Our Ref: LU/234/19/HH
Your Ref:

Town & Country Planning Act 1990 (as amended)
Town & Country Planning (Development Management Procedure) (England) Order 2015
Application for Planning Permission for Works or Extension to a Dwelling

Development Ground floor side and rear extension, first floor rear extension
Location Parkfield Worthing Road Littlehampton

PROPOSED SITE/BLOCK PLAN 1:500

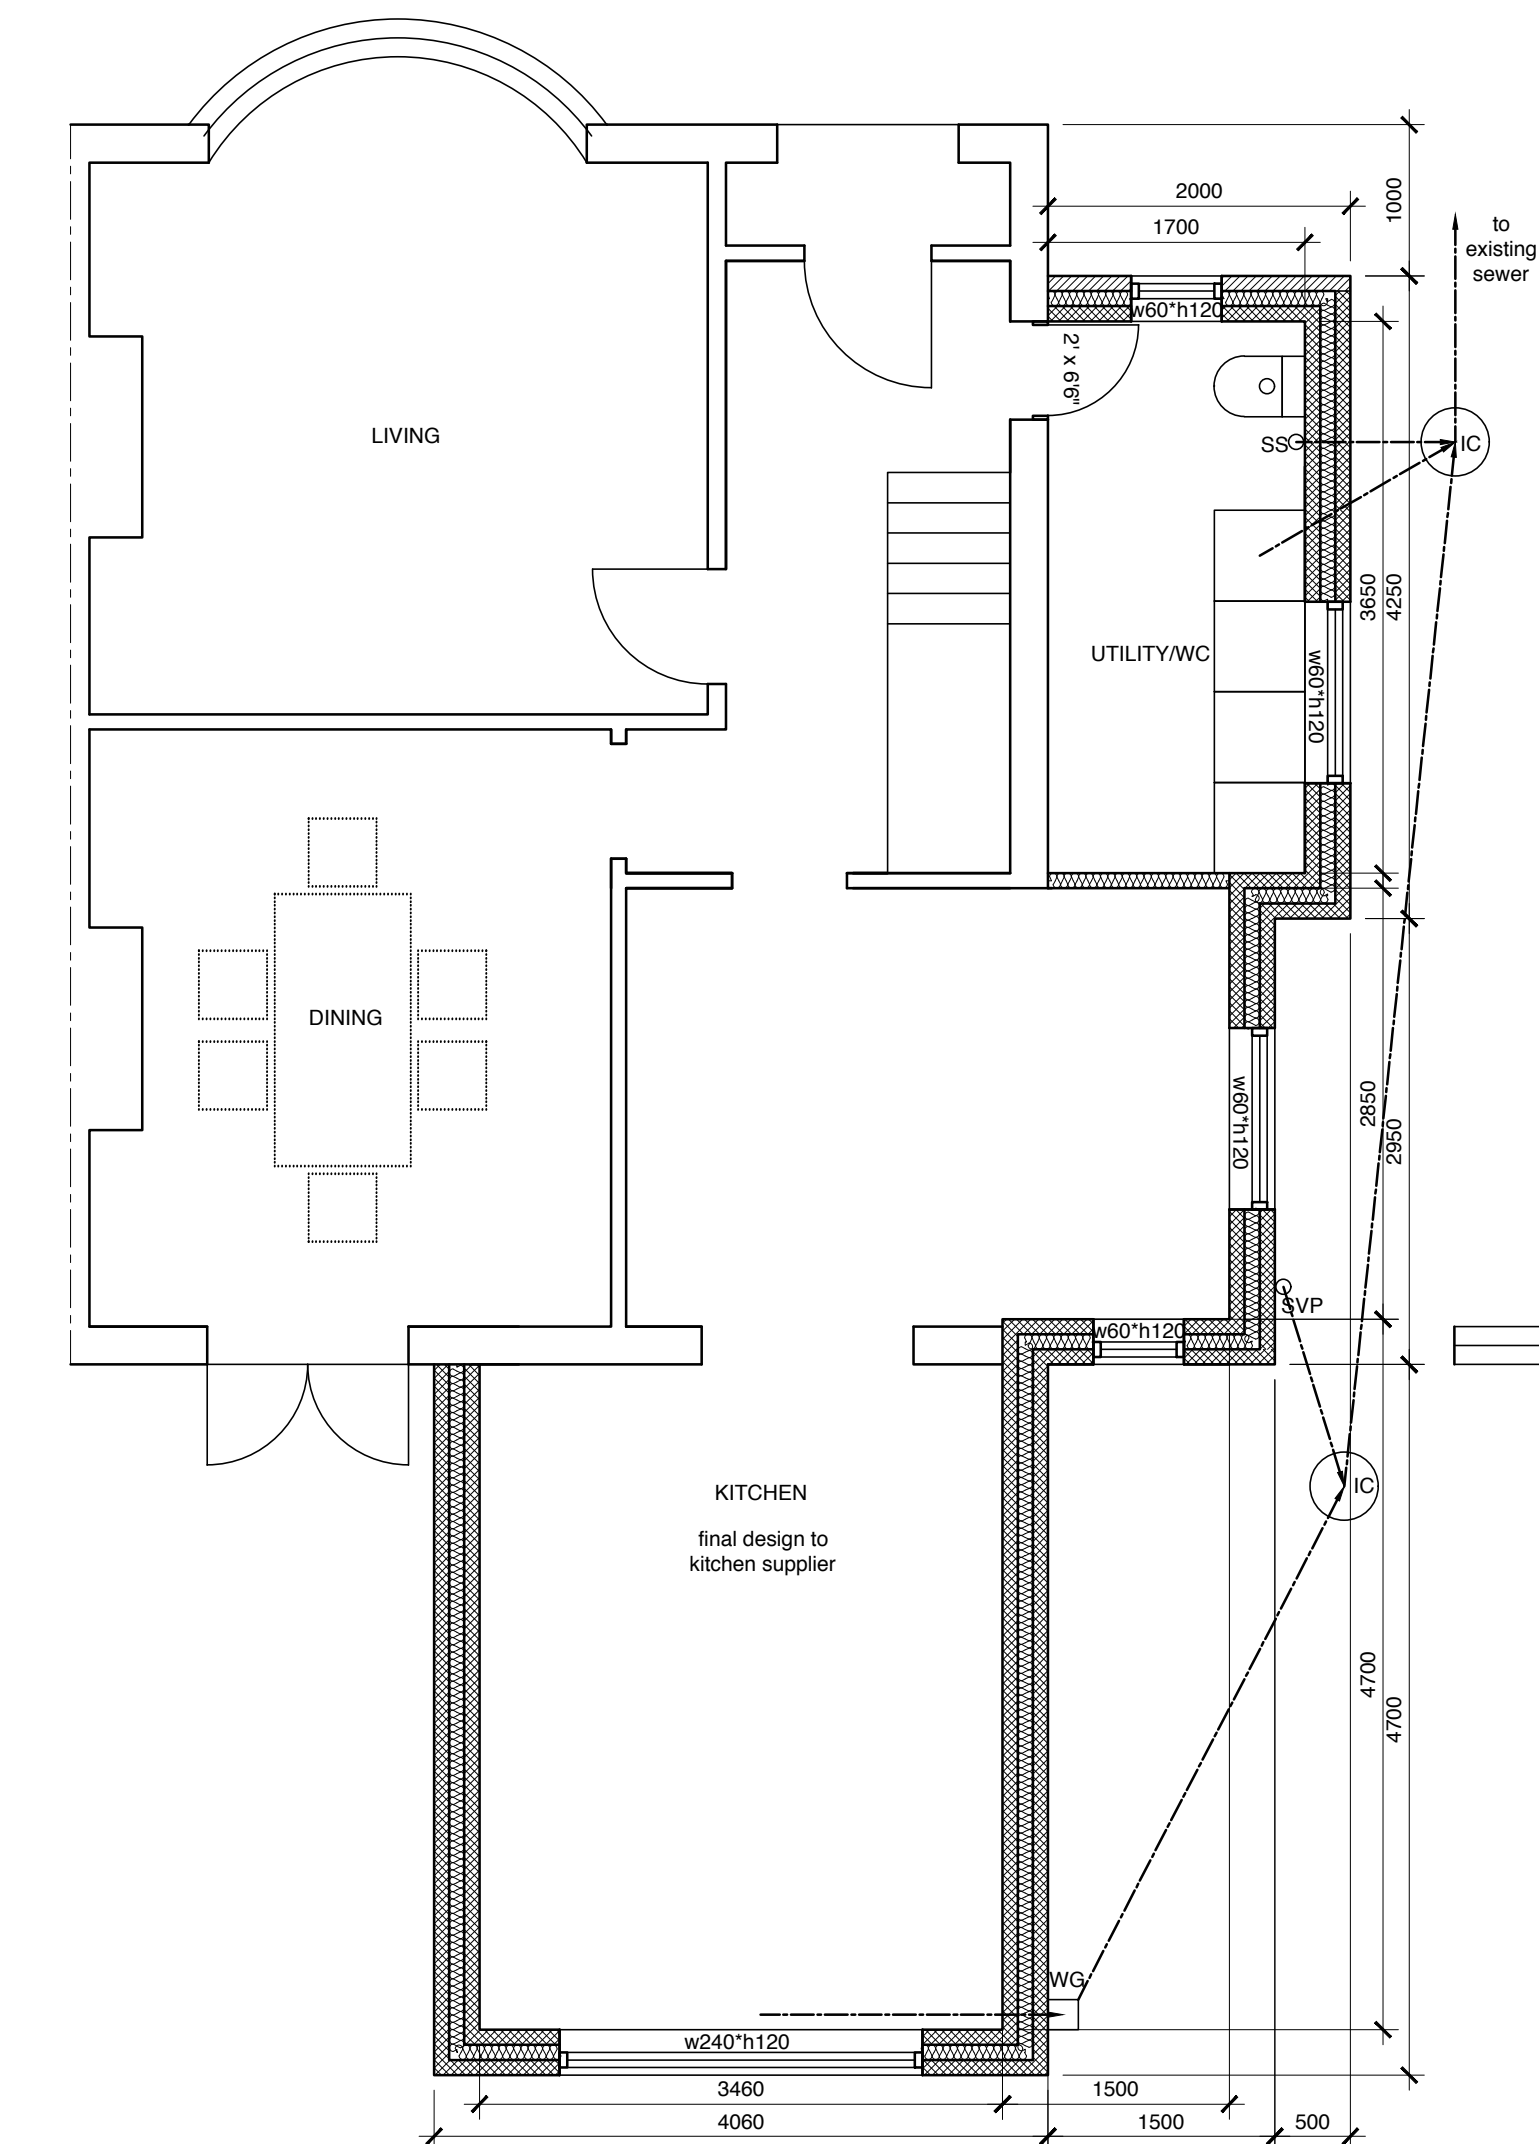
Block Plan

You are required to include dimensions to the front and rear boundaries on the block plan.
